Dean Moor Solar Farm

Cultural Heritage Technical Note

August 2025
Prepared by: Stantec
PINS Ref: EN010155
Document Ref: D2.33
Revision: 1

Rev: N/A

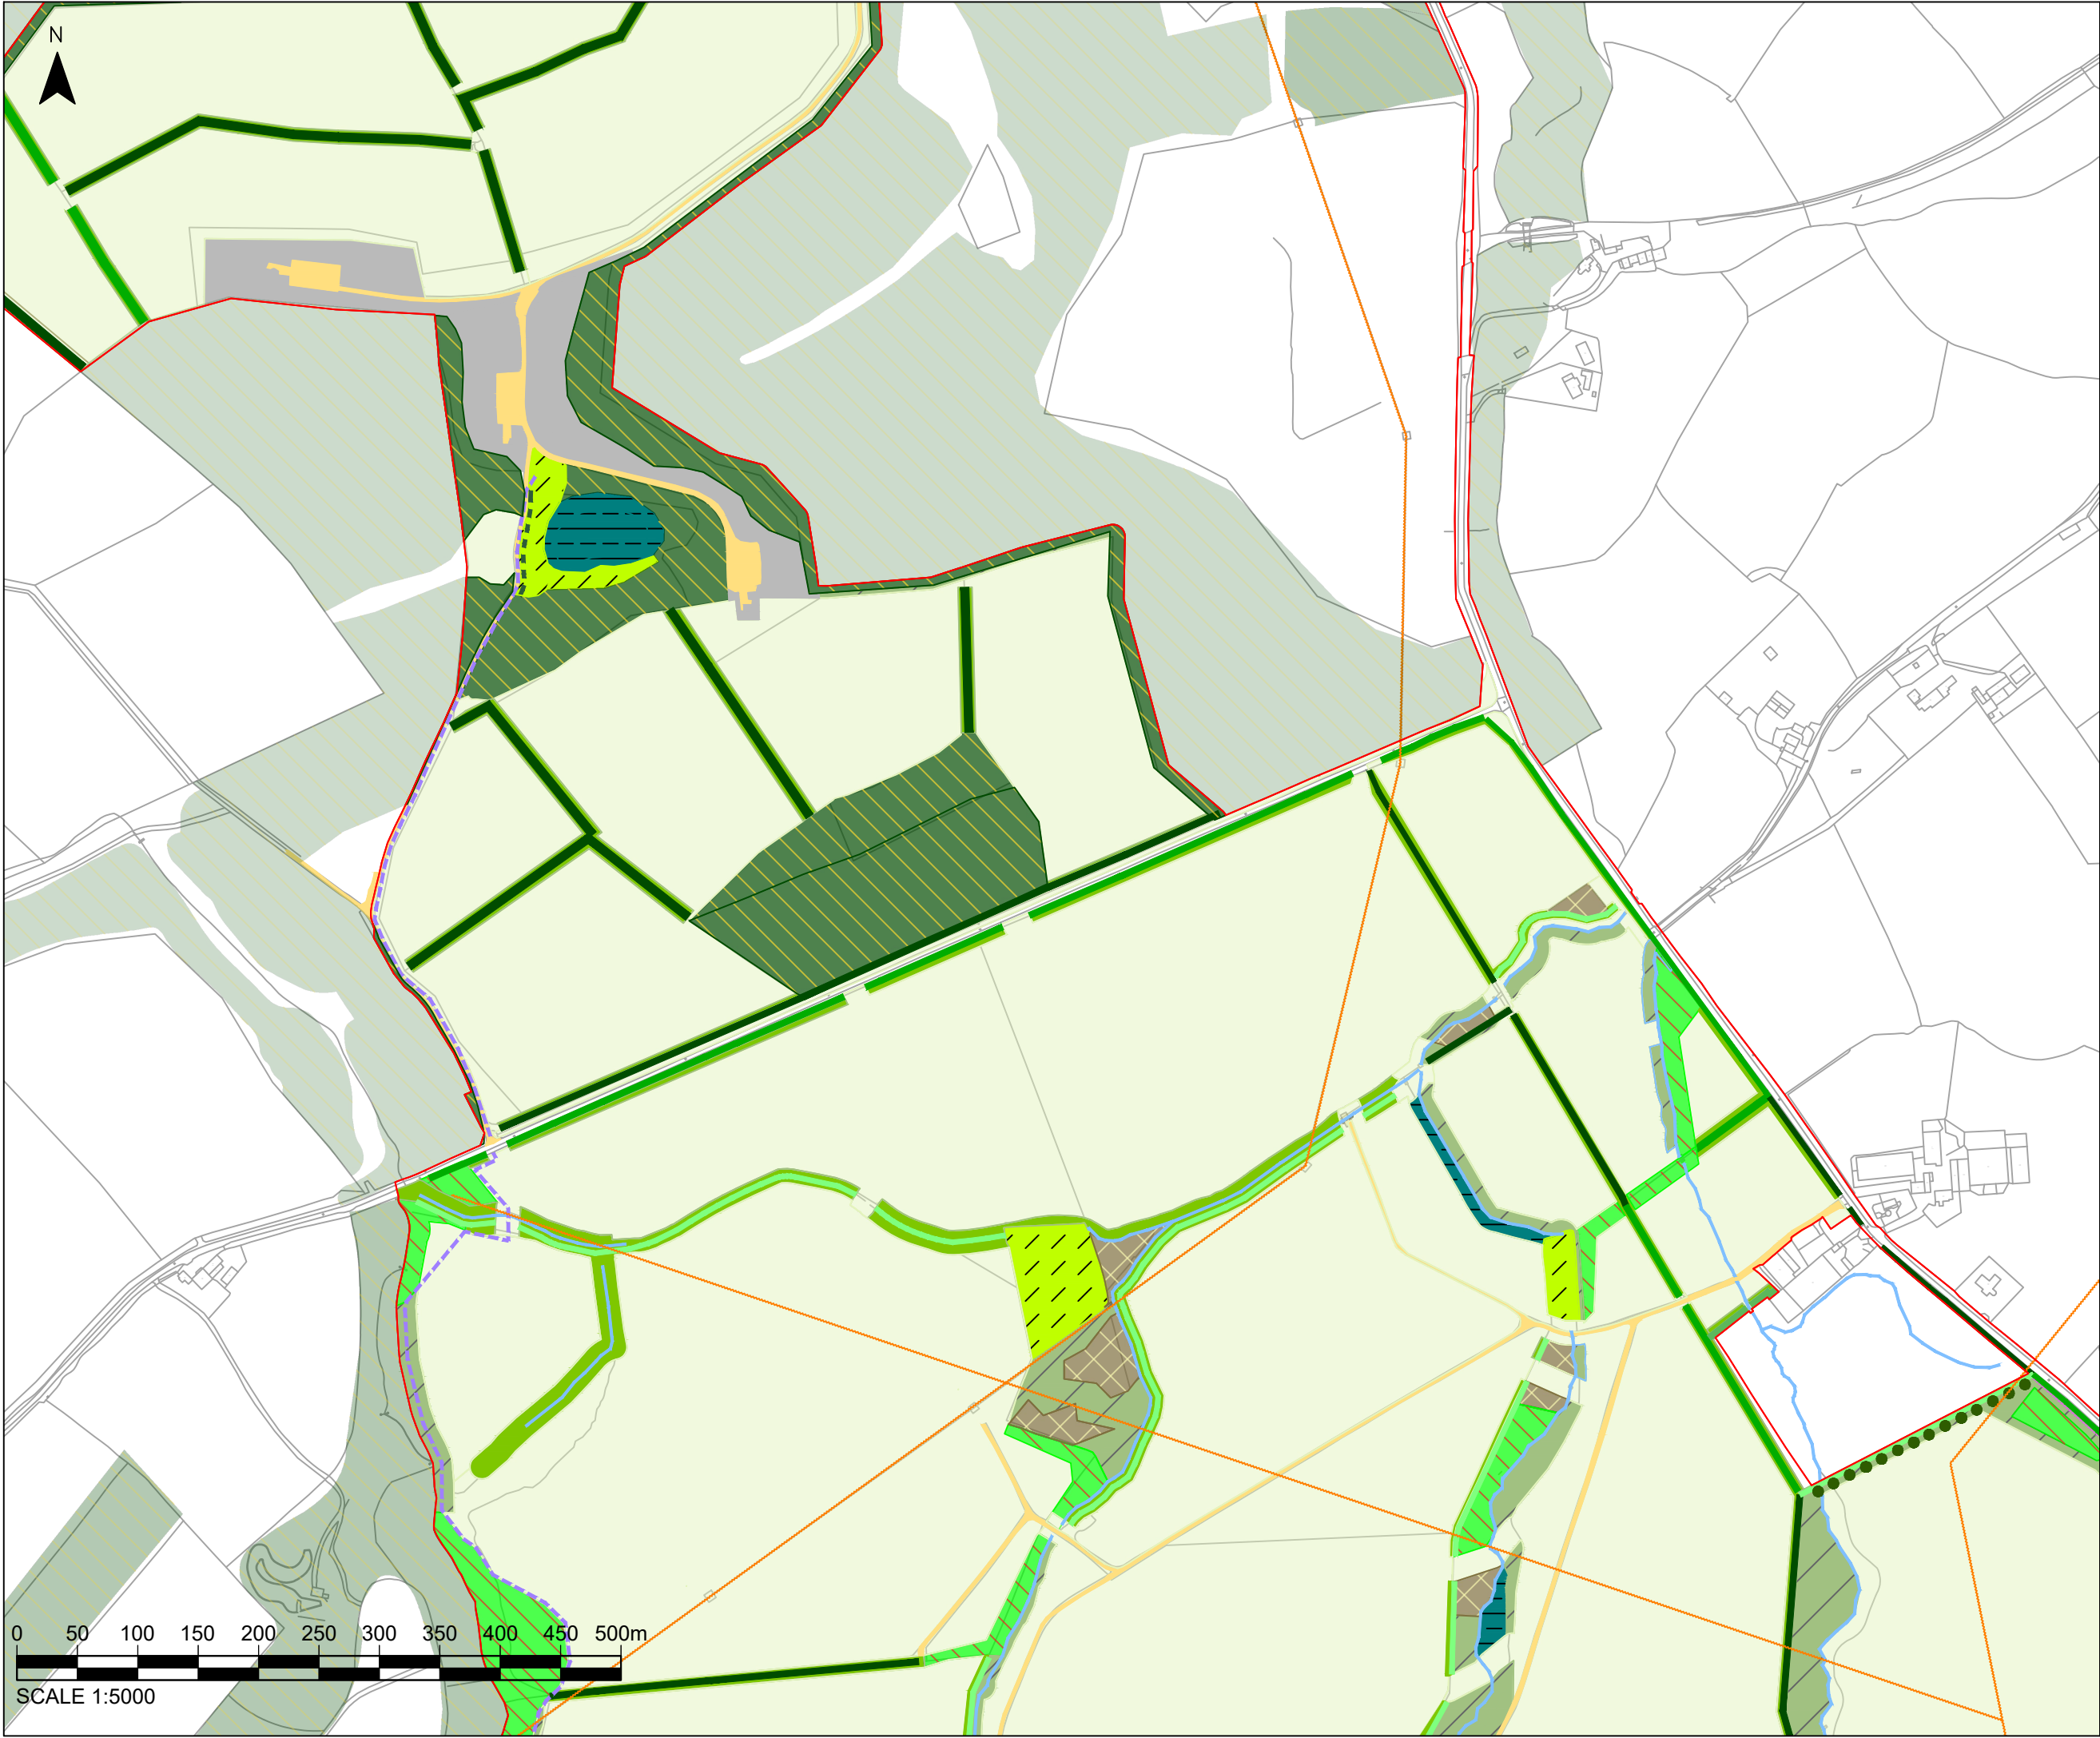
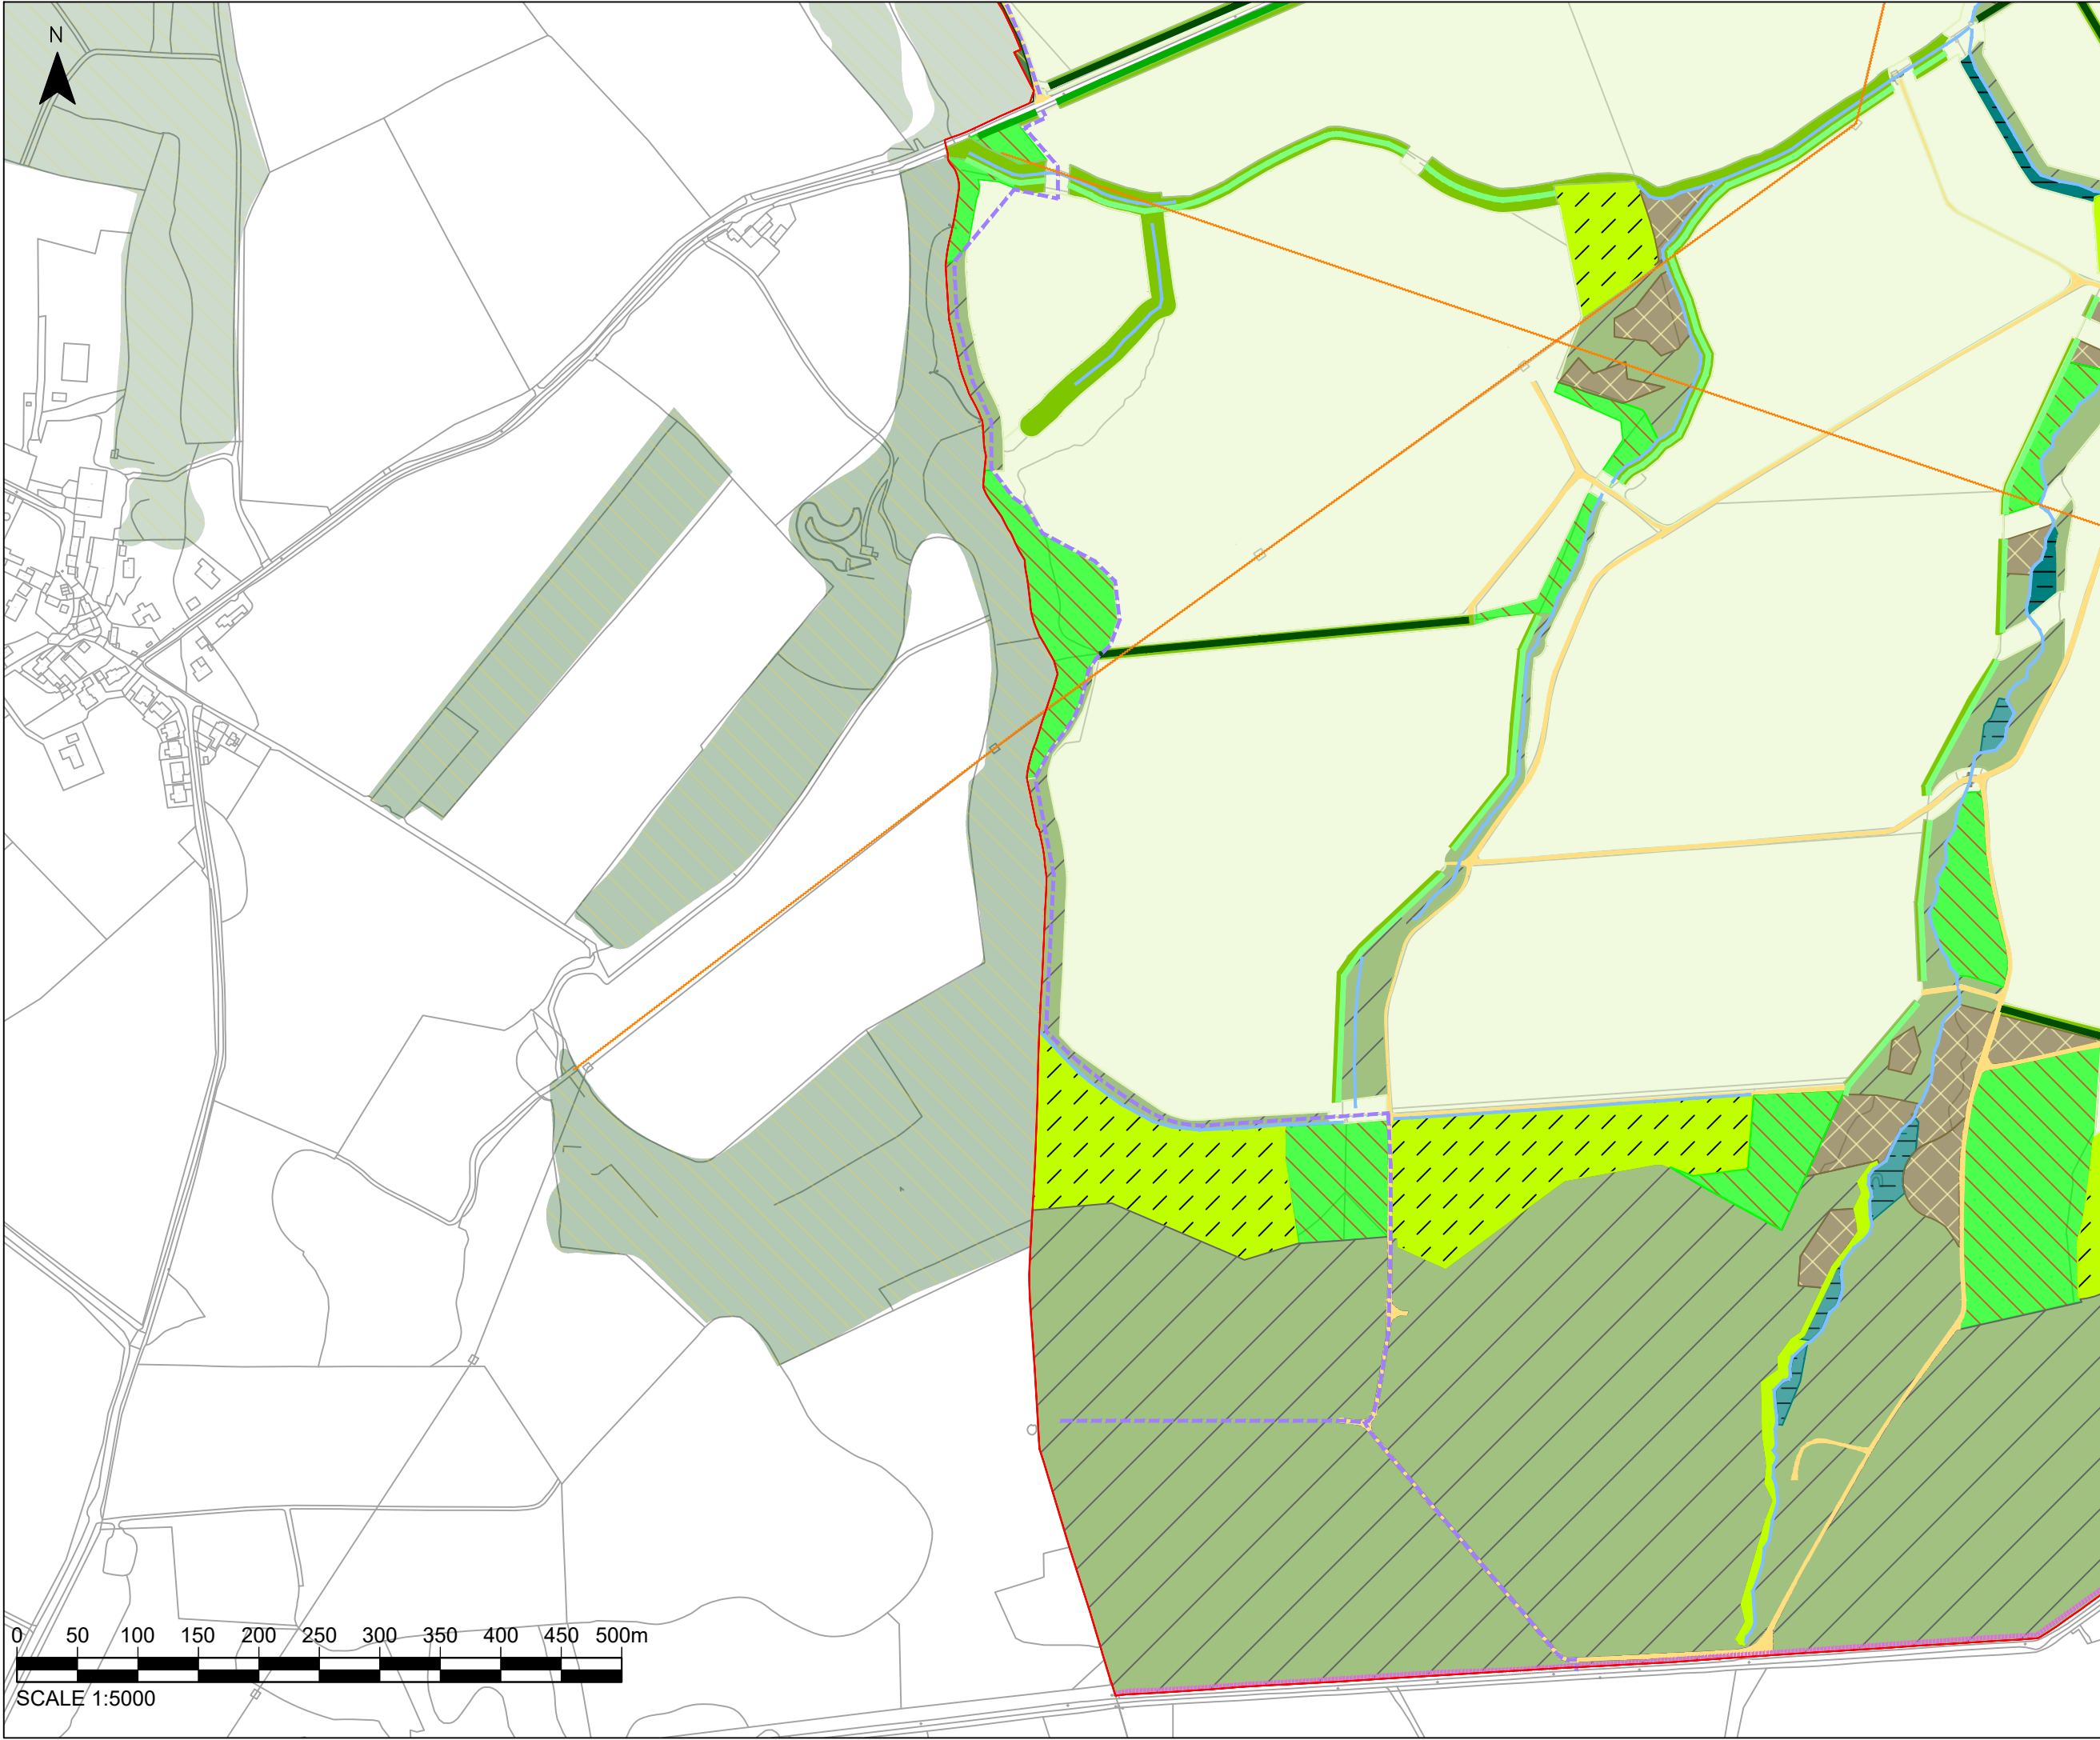
- 1.1.3 *‘Table 2.1 Grade II listed buildings and Grade II Registered Parks and Gardens should be placed in the ‘High’ category and not the ‘Medium’ category. Para 2.2.8 makes reference to the use of Design Manual for Roads and Bridges LA 106 as it ‘provides a useful framework for cultural heritage assessment’. As such, the criteria contained within Design Manual for Roads and Bridges LA104 would have been more appropriate – which assigns a ‘High’ value to receptors of ‘national scale’. Grade II listed buildings are designated to their architectural or historic interest on a national scale (as are Grade II Registered Parks and Gardens).’*

- 2.2.3 The receptor is situated approximately 150m from the Site boundary. The farmhouse has extensive views across the adjoining landscape, due to the surrounding topography; with the farmhouse situated on a slope which falls away towards Dean Moor. The views from the rear of the property looking across the Site will be affected by the Proposed Development. Whilst the panels comprise low level infrastructure, they will foreshorten long-distance views, resulting in a change to the characteristics of the receptor setting and eroding the rural open nature of the landscape

- 2.2.4 The landscape mitigation proposes a green infrastructure buffer, which has been included within the Works Plans [APP-007] and is reinforced by proposals in the Landscape Strategy Plan (LSP) (ES Figure 7.6.1 – 7.6.5) [APP-088]. This buffer surrounds the part of the Site in closest proximity to the receptors with proposals to include new landscape structural elements (trees/scrub) to help screen the most direct near-distance views.

- 2.2.5 The LSP also includes reinforcement of existing hedgerow field boundaries across Areas A and B, which are expected to also help break up views and prevent a ‘block’ appearance. As per the Design Parameters Document (DPD) [APP-049] the Solar PV infrastructure (Work No. 1) will have vegetated ‘aisles’ between rows of solar panels which to avoid the appearance of a continuous façade, especially when viewed from a partial or full side elevation of the arrays which will be oriented with panel facades facing south, as is the case from this receptor to the west/north-west.

- 2.2.6 These measures ensure that the visual impact from the closest panels (located at approximately 150m from the receptor) is reduced. In summary, it is considered the proposed landscape mitigation would minimise the impacts caused by the Proposed Development.
